Your ref: A/31/19/PL

8th April 2019

Application for a single Dwelling.
Land North of Ashurst, Plot 9, Ham Manor Way, Angmering.
Planning Application Ref: A/31/19/PL

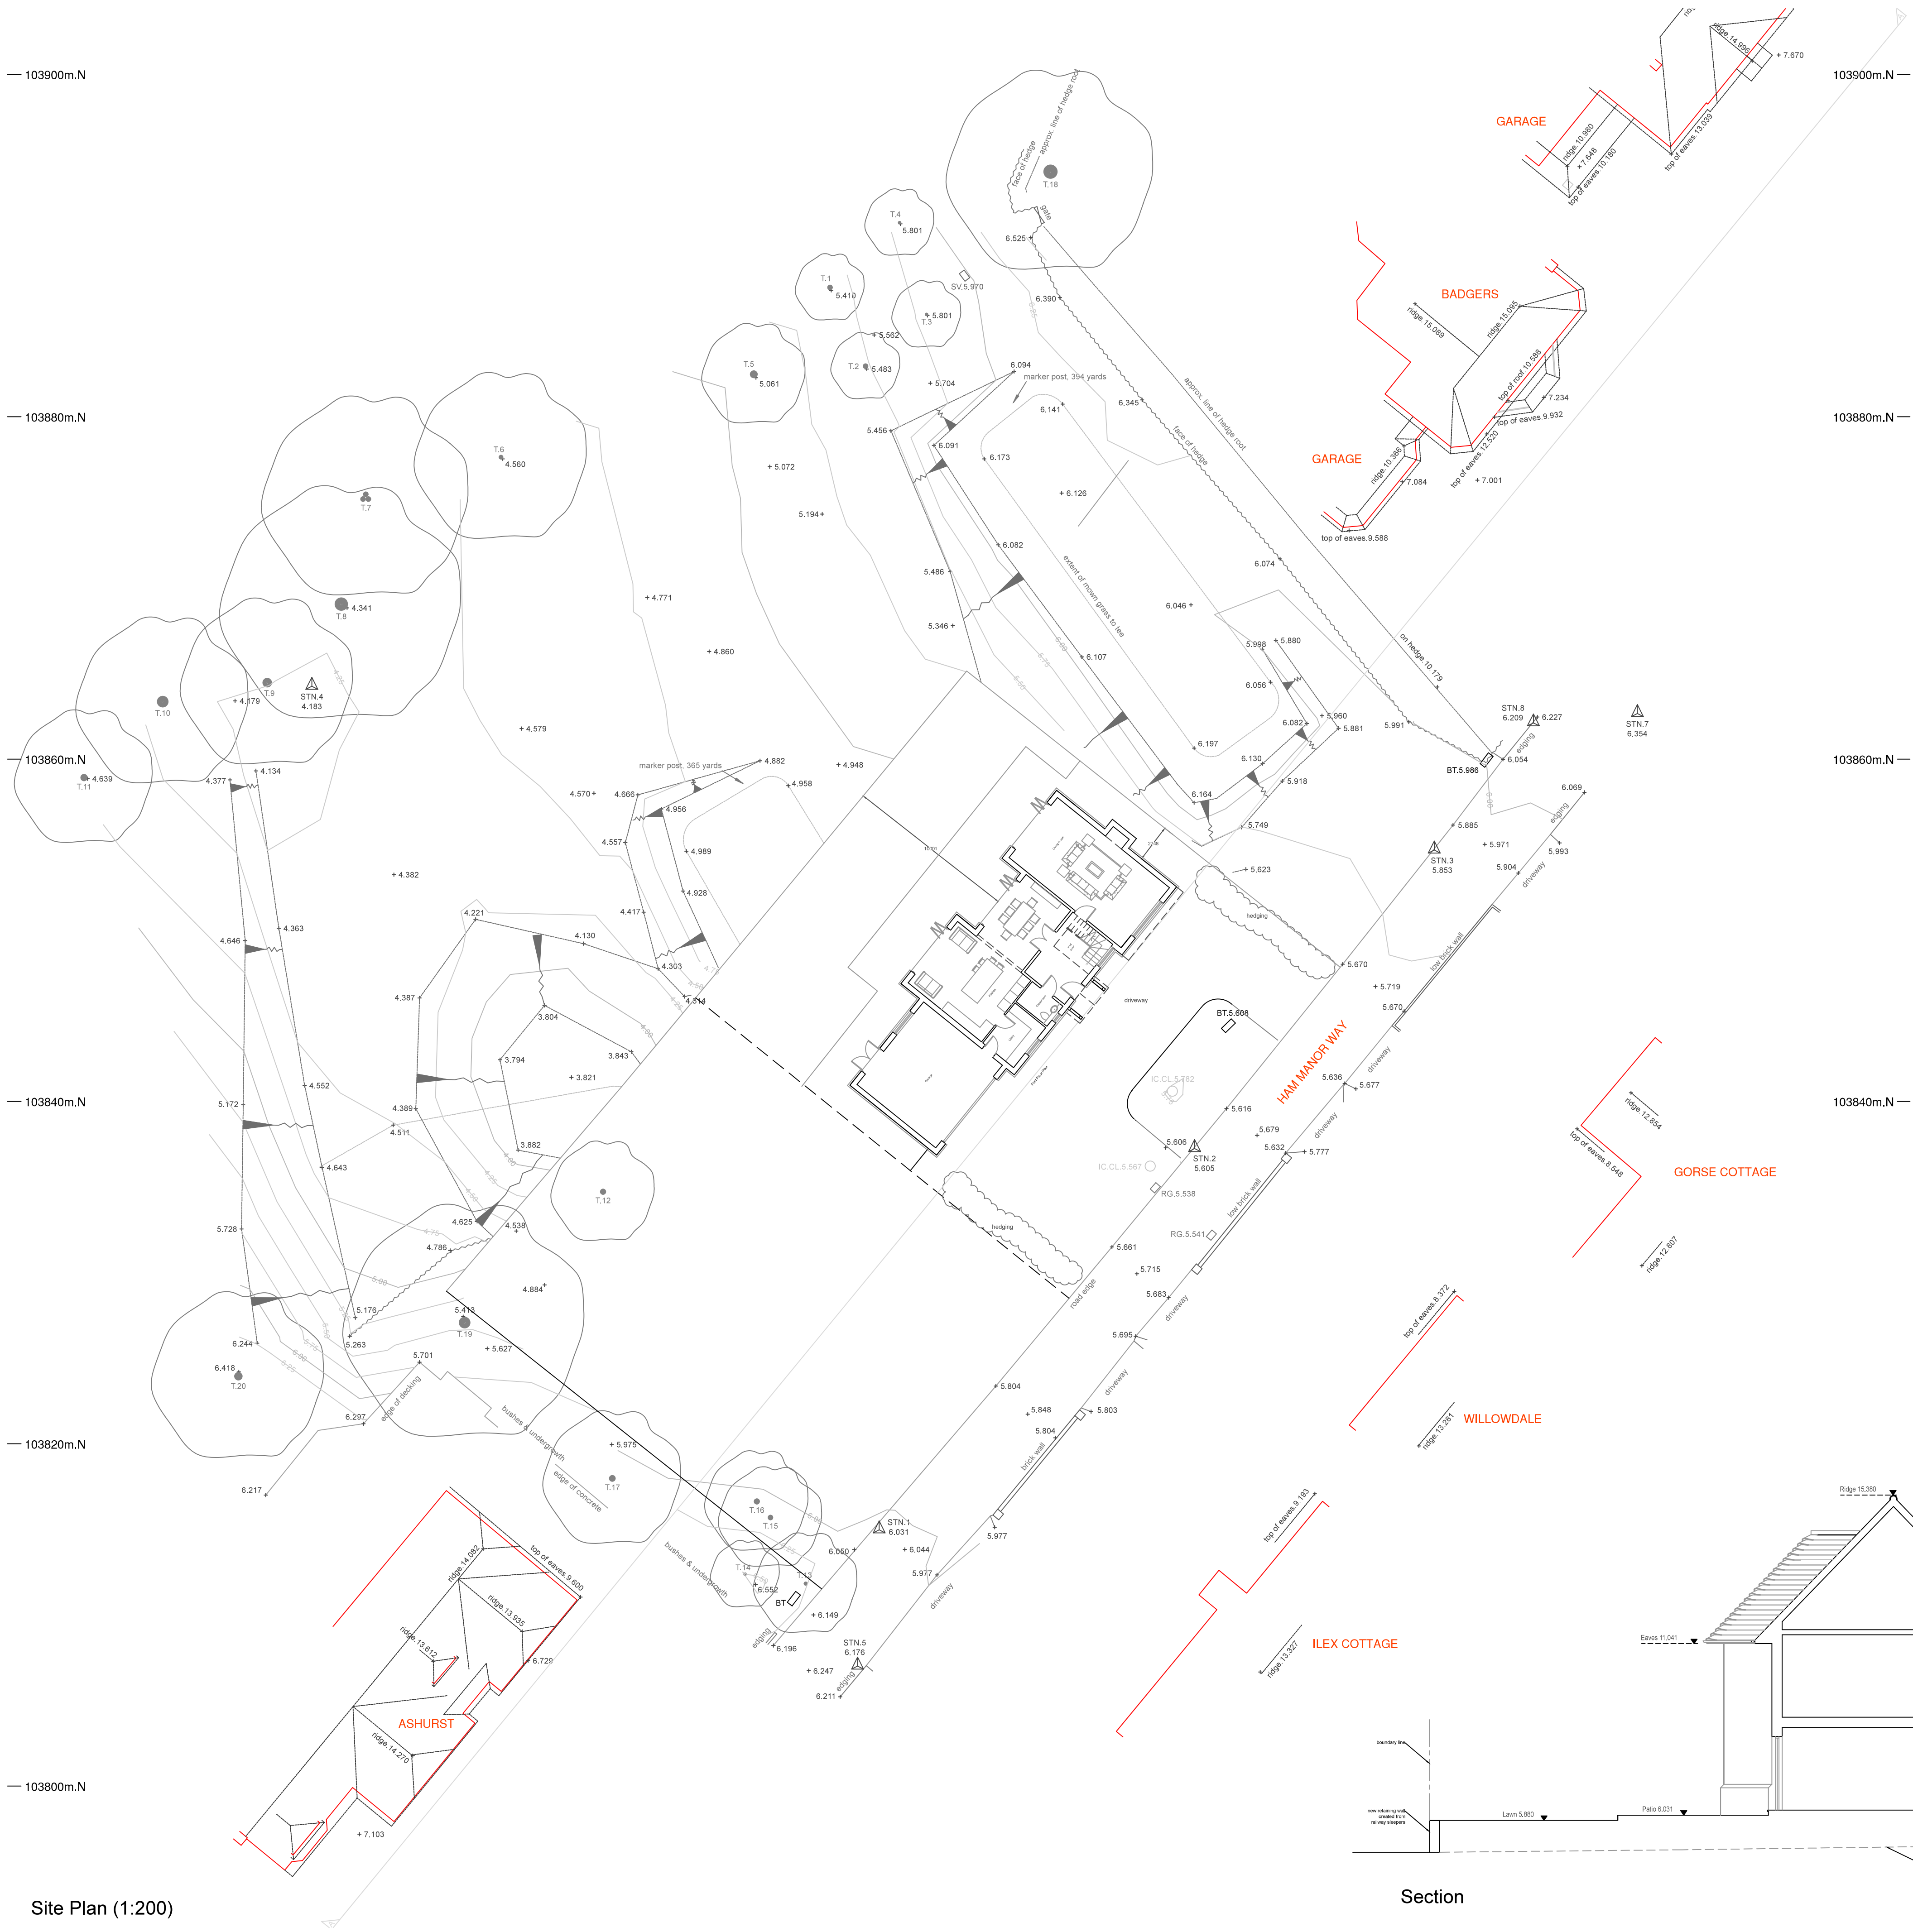
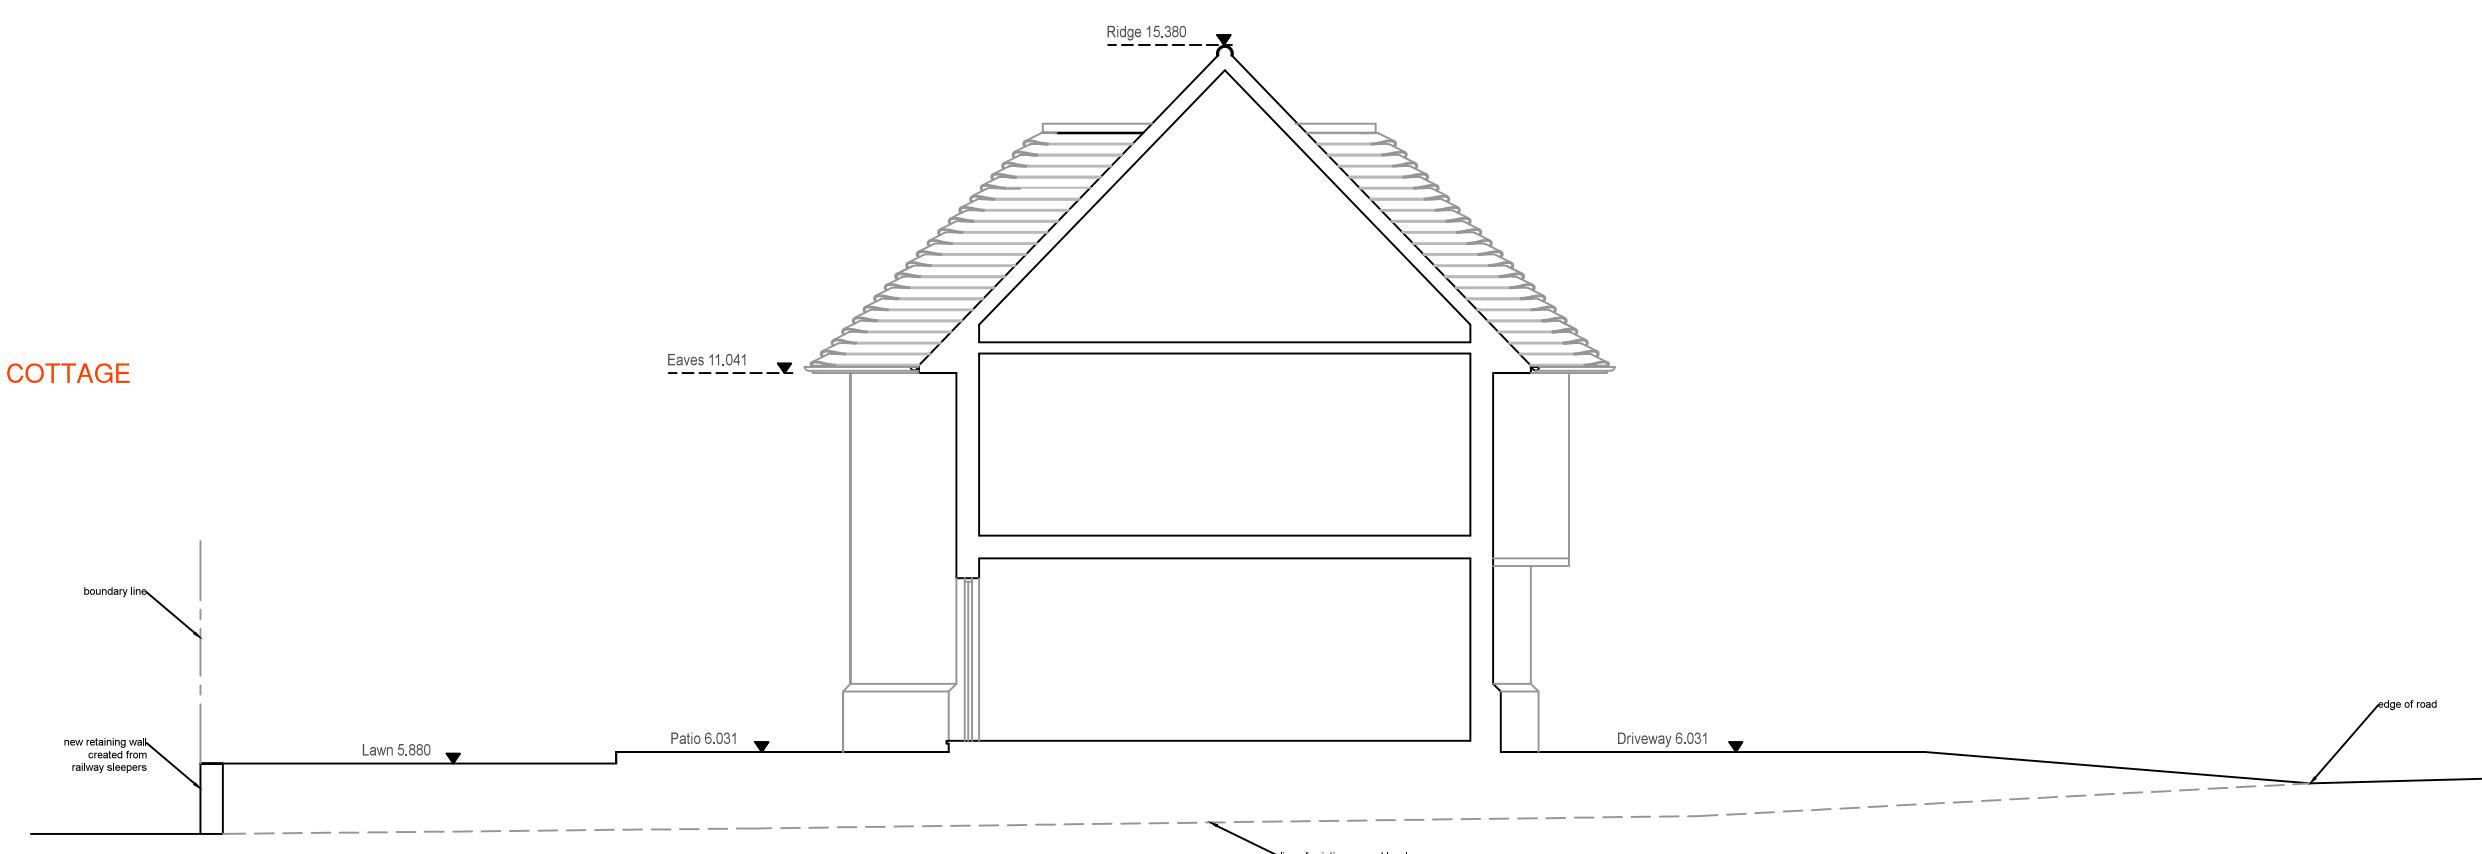
In assessing the impact of this proposal there has been a decision made on the earlier application for two dwellings on the land, granted as a Certificate of Lawfulness. In comparison, this proposal is for a single unit but it takes virtually half of the land itself across the width of the plot as shown on the application A/212/17/CLP. Whilst it is not of the same depth as relative to the application which it seeks to replace in my submission this is irrelevant to the consideration of the impact of the width of the dwelling now proposed and the damaging effect that this will have on its host environment. The applicants in this case have sought to increase the height of the land and to create a level aspect across the width of the plot. Sadly no details have been submitted to fully indicate what happens to the soil on the north of this site as this could become vital given the limited space between the north elevation of the proposed unit and its common boundary, especially where there is minimal

space available where the new chimney has been introduced. On the southside this appears to run into existing ground levels but the ground falls from east to west and this appears to lack certainty as to just what is intended. This situation affirms problems that arise out of the intentions to raise the ground levels within what is a very mixed level of ground with changes that occurring both from both south to north and east to west.

Same page "Access". This does not appear to be correct as ground levels are acknowledged on the submitted drawings to be made up to create a more level plot.

Drawing Title:
Proposed Plans, Elevations and Street
Scene Elevation
Drawing Number: 1202.01.c
Scale: As stated printed @ A1
Date: 06/02/2019

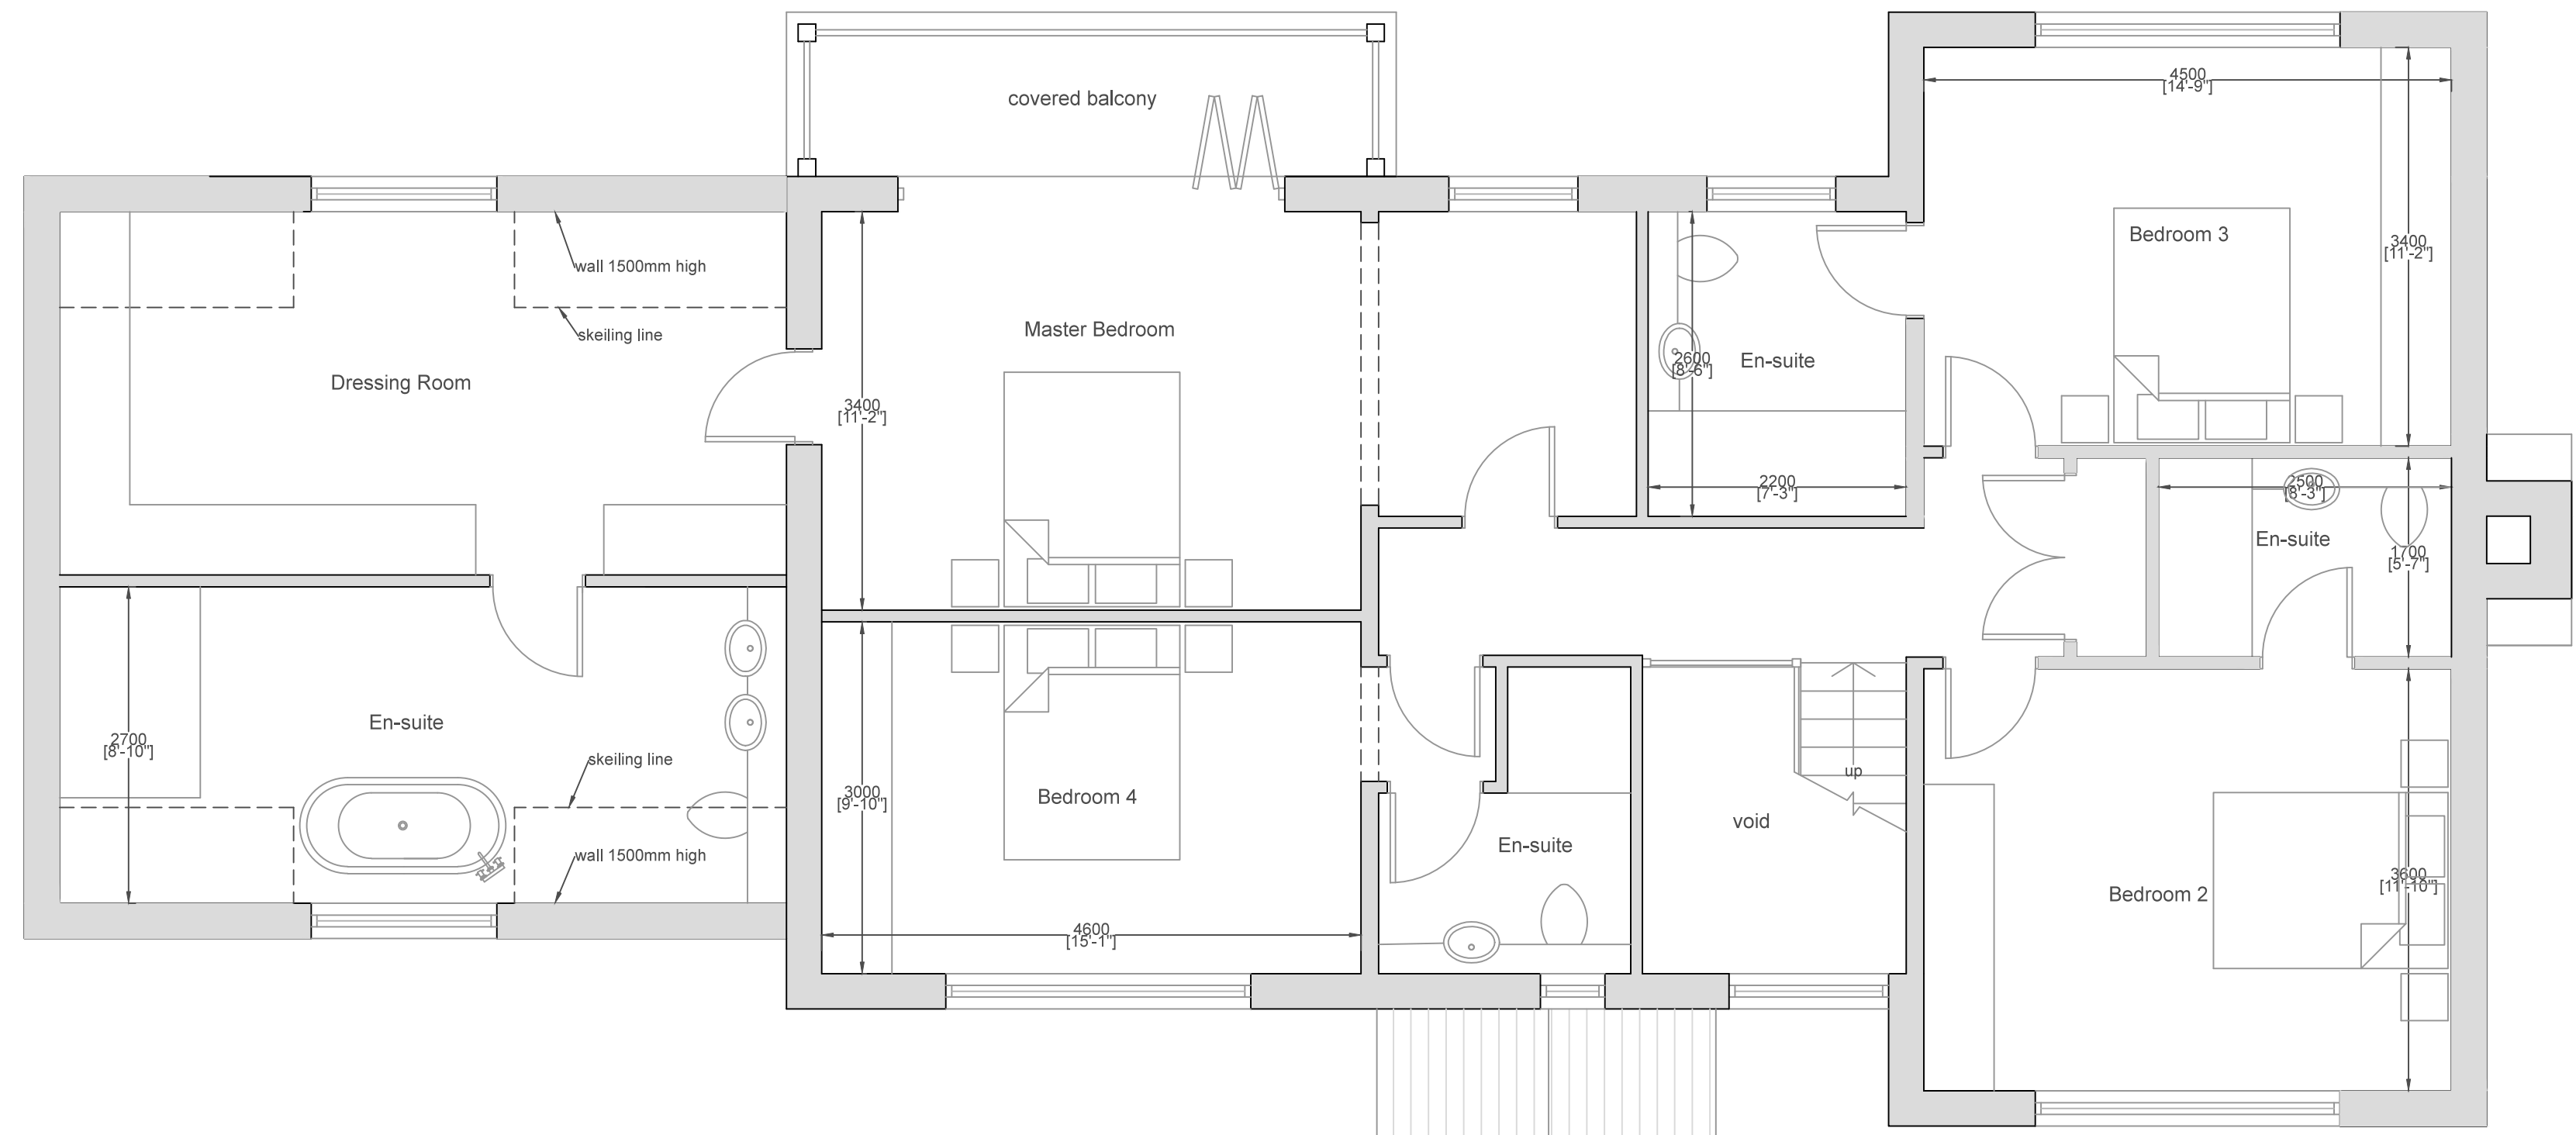
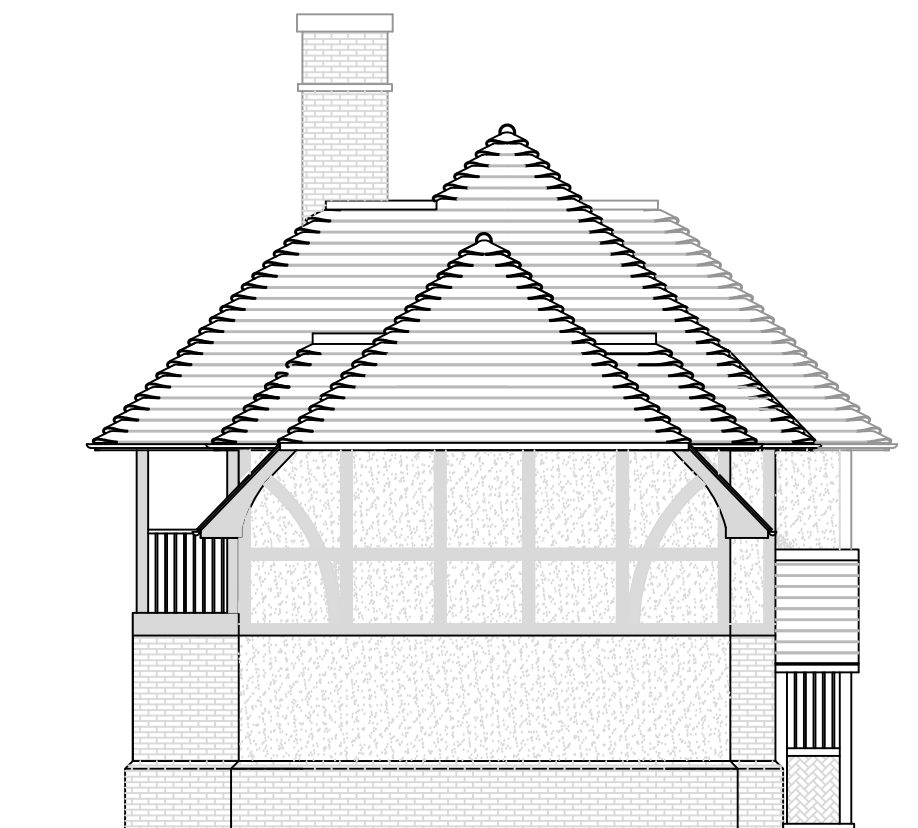
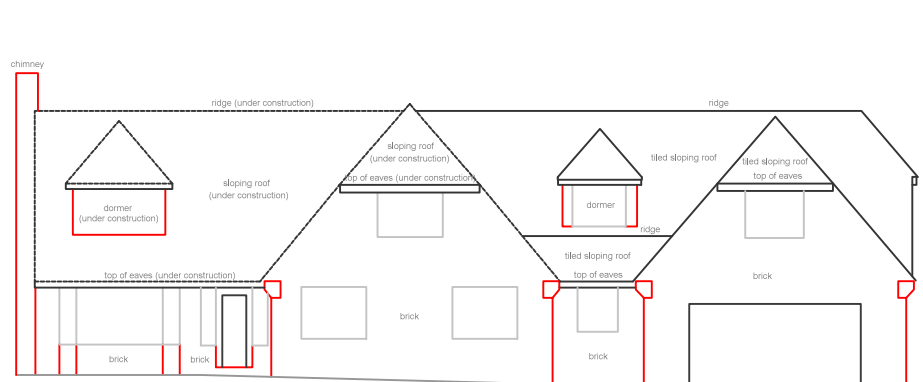
My next concern is the situation across the frontage of the site. The northern 75% of the building is in full two storey height, whilst the south section of this frontage is shown at 1 1/2 storey height to eaves level. In assessing the impact of the front elevation this is clearly further forward, both of Ashurst to the south and Badgers to the north. This is not helped at all by the submitted block plan being well out of date and not showing the more recent changes to Ashurst to the south. The consequence of all of this is that the building now appears more prominent being closer to the highway, with no verges shown across the existing frontage of the site. My view is that the front elevation now needs to be set back, as a matter of principle regardless of the design and aspect of the building, with the correct distance also shown for the depth of the rear elevation to the common rear boundary. As it stands this dwelling is now totally out of character in terms of the full impact of the frontage of the development upon the host environment.

Finally, in assessing the scale and footprint of the building there is the third dimension to address. In determining the appeal decision, which must also be a vitally important material consideration in considering any dwelling on this land, the Inspector wrote very stringent views on the potential of these plots against the 1957 consent. In short, he was expecting the type of construction of a chalet style dwelling with eaves level above the ground floor of the dwellings and a sense of space about both dwellings. This proposed dwelling fails miserably against these requirements: it is too big; far more prominent; and of a rather grand appearance rather than respecting the design and style of all of the dwellings opposite and to the south. Comments made relating to the dwelling to the north should be forgotten in this instance as they are simply irrelevant to the consideration of the proposed dwelling in its existing context. Furthermore, let us not forget, this dwelling sits on just the northern element of the double plot as existing from the A/212/17/CLP application which, without the introduction of a 106 agreement as a matter of principle, to remove the potential to come back another day for the second unit. In this respect one cannot determine the principal without having regard to the introduction of a second unit on the southern plot. The existing plot width between the two is a reduction of 10 feet (3.2 m) of the width of this unit and the same building, but 3.2m narrower, could then be erected to the south. This would result in an absolute disaster upon the host environment in terms of the scale, visual impact and a form of development which in this respect would be wholly out of character with the existing.

In short this building is simply far too grand for this site. It is built to be the full extent of the boundaries with the minimum (or less) space provided to properly contain the site. It would be wholly out of keeping on its own, let alone without the introduction of a slightly smaller unit to the south being built another day at some time in the future.. In this respect I would submit that the development is wholly contrary to the Arun Local Plan Policies HD1 and 5 and also to DM1 and 3.

On the unnumbered page 4, (scale), it is a matter of fact that the dwelling is taller than Ashurst and more importantly all of the neighbouring properties opposite the site. There is nothing shown within the submitted plans to in anyway hide the dwelling from its location and in this respect with no apparent screening available the perceptive height of the building will always be read in connection with the dwellings opposite and with Ashurst to the south.
